**KIRKLEES METROPOLITAN COUNCIL
INVESTMENT & REGENERATION SERVICE**

DELEGATED DECISION TO DETERMINE PLANNING APPLICATIONS

Reference No:	2024/62/91470/W
Site Address:	1, Annottes Croft, Dalton, Huddersfield, HD5 9RJ
Description:	Erection of two storey side and single storey rear extensions with front porch
Recommending Officer:	Joanna Rednall

DECISION – Full Conditional Permission

**PROPOSED SIDE ELEVATION**  
(North East)

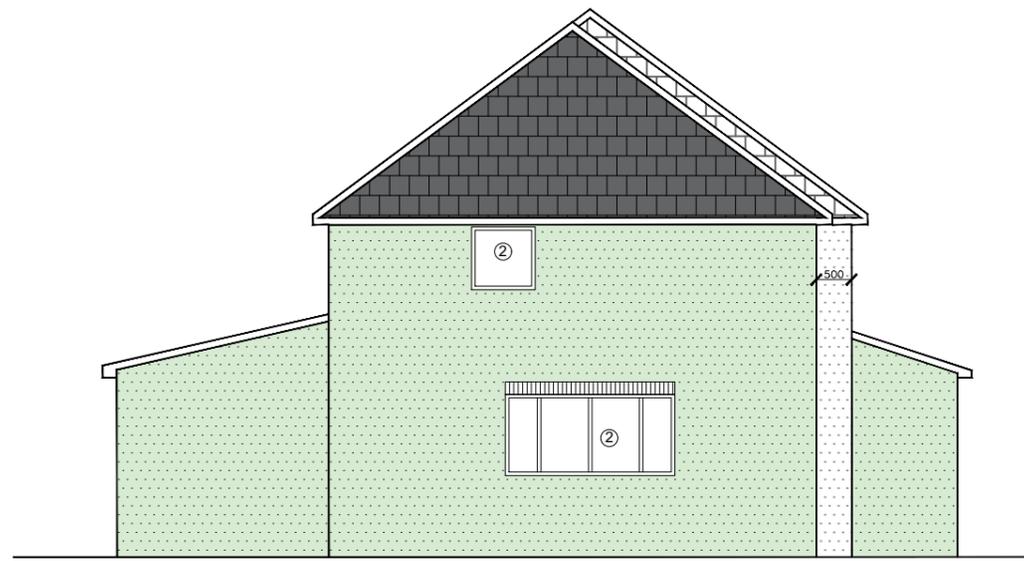
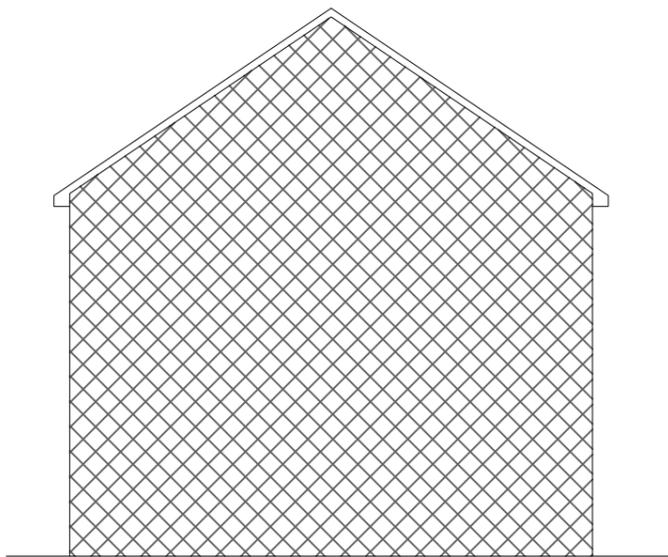
The design of the proposal is such that the two-storey side extension would be set back from the front elevation of the property by 0.5 metres, with a roof ridge which would be set down by 0.3 metres from the roof pitch of the host pitch. With regard to the width of the proposed extension, following amendments, the 3.2 metre projection is considered acceptable, measuring no more than half of the width of the host dwelling and therefore appearing visually subordinate to the original house. The setback and set down of the extensions to the host encourages a retained sense of space to the front, helping to retain a subservient appearance within the wider street scene.

The siting of the extension would retain a minimum separation distance of approximately 0.3 metres from parts of the shared boundary to retain external access to the rear of the property. Although contrary to SPD guidelines, the proposed extension would replace an existing outbuilding along the shared boundary. There would be space remaining within the site to the front and side for the extension to not dominate the site.

The application site occupies a corner plot. The extension has been designed to create two frontages with openings within both the front and side elevations, relating well to both street frontages. The two-storey side extension is set back from the existing building line on both Annottes Croft and Arkenmore, therefore adding to its subservient nature.

The proposed two storey extension would occupy a position approximately 0.3 metres from the communal boundary shared with 6, Arkenmore. The two-storey extension would be partially screened by an existing outbuilding within the curtilage of this neighbouring dwelling. Given these factors, it can be concluded

The only proposed glazing that could impact this neighbour would be the windows within the two storey side extension. However, these would face the driveway of No.6 and the wider street scene on Arkenmore, therefore it is not considered that this element of the proposal would result in any future harm to the neighbour's residential amenity over the existing.

PROPOSED FRONT ELEVATION
(South East)

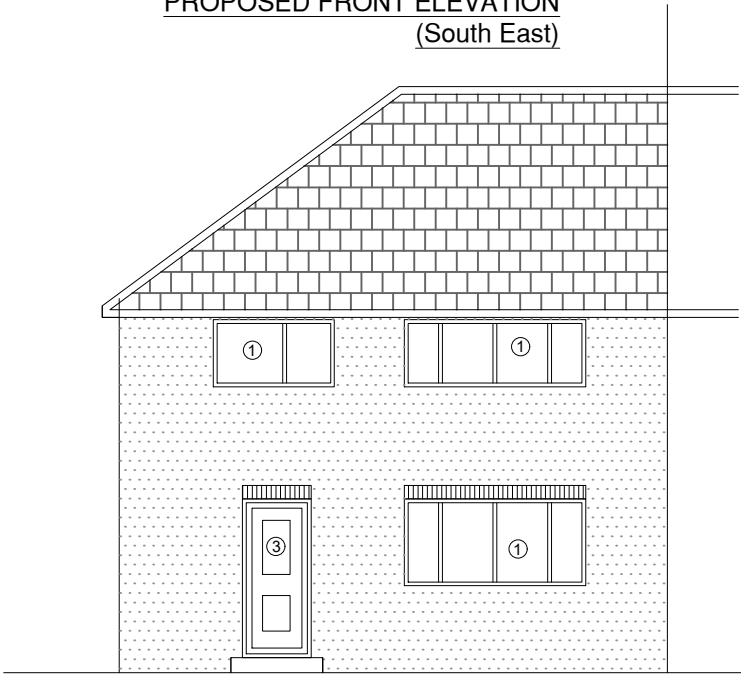
The size and scale of the single storey rear extension is considered to be a proportionate addition to the host property. The extension would project 3 metres from the rear elevation and would not exceed 4 metres in height. Although contrary to SPD guidelines, the extension would be sited less than 1 metre from the shared boundary with the adjoining neighbour. However, given the 3-metre projection, there is a realistic fall back position that this element of the proposal could be achieved through permitted development. This element of the proposal is therefore concluded to have an acceptable visual impact.

The proposed single storey front extension would project 1.5 metres from the front elevation of the original dwellinghouse. The enlargement would incorporate a lean-to roof and would be finished in render to match the host property. The extension would be modestly proportioned and would appear subservient to the original build. Furthermore, the enlargement would be set back from the highway and would not appear unduly prominent from public vantage points. It is therefore considered that the proposed development would respect the character and appearance of the host property and wider street scene.

While it is noted that the enlargement to the rear would introduce 3 openings closer to this neighbour, the glazing is not considered to result in undue levels of overlooking. This is a result of the separation distance and difference in land levels present.

It is noted that the single storey element adjacent to the boundary with this neighbour would impact upon a 45 degree line when taken from the centre of the cill of the nearest window in the rear of no.3.
